Cory Decarbonisation Project Case Team
Planning Inspectorate
CoryDP@planninginspectorate.gov.uk
(Email only)

MMO Reference: DCO/2023/00007
Planning Inspectorate Reference: EN010128

Planning Act 2008, Cory Environmental Holdings Limited Proposed Cory Decarbonisation Project Order

This document comprises the Marine Management Organisation's ("MMO") initial comments in respect of the above Development Consent Order application ("DCO Application") in the form of a relevant representation.

Dredging Coordinates		
ID	Northing	Easting
P1	181045	549833
P2	180877	550350
P3	180775	550324
P4	180734	550244
P5	180803	550106
P6	180797	550086
P7	180784	550002
P8	180845	549879
P9	180891	549871
P10	180985	549804

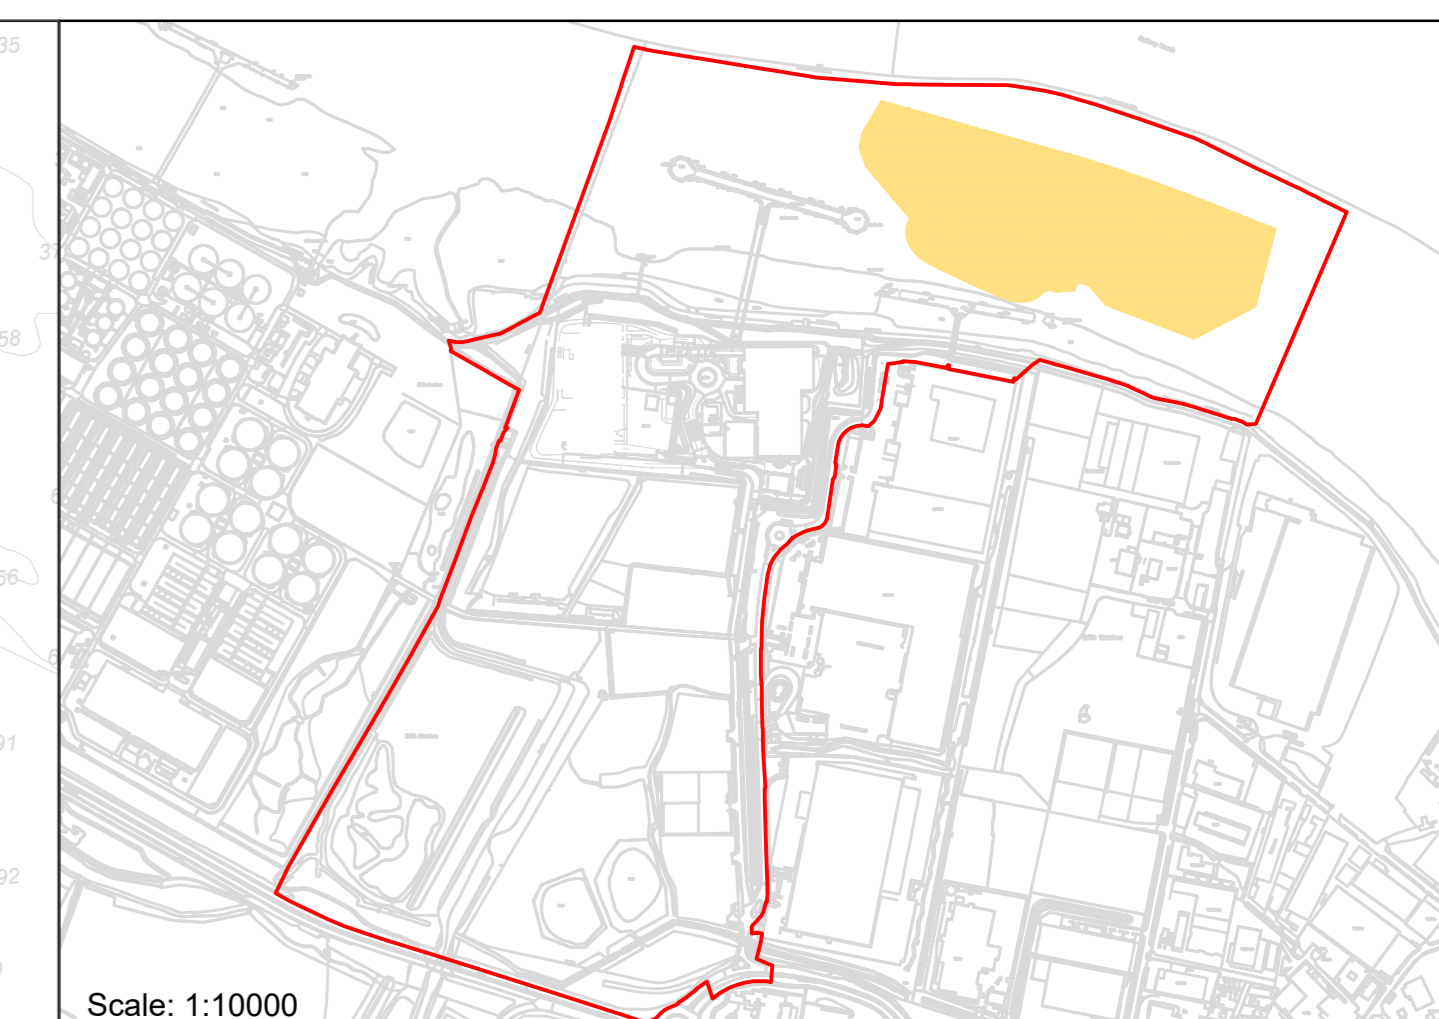
3	Details of such licenced marine activity (3)	<p>This provision is very broadly drafted. The MMO considers that exact coordinates should be included to detail where the licensed activities will be carried out.</p> <p>The MMO has concerns regarding this drafting, in particular the general right to alter, modify, remove or replace any work or structure at (3(2)(b)(i)), very broad rights to carry out excavations, scouring and dumping at (3(2)(b)(ii)), dispose of materials (2)(b)(iii) and remove any vessel whether lawfully or not (3(2)(b)(iv)). The MMO requests that these are amended or clarified as to whether these will be addressed further in the method statement. As drafted, these are very vague and the very broad nature of the provisions as they stand, especially given the absence of the other standard plans and statements, the MMO would expect to see references.</p>
	How long is the licence to remain in force?	<p>The MMO would expect to see provisions covering how long the licence will remain in force for, for example:</p> <p><i>“This licence remains in force until the authorised project has been decommissioned in accordance with the programme approved by the Secretary of State under section 106 (approval of decommissioning programmes) of the 2004 Act, including any modification to the programme under section 106 (approval of decommissioning programmes) of the 2004 Act and the completion of such programme has been confirmed by the Secretary of State in writing”.</i></p>
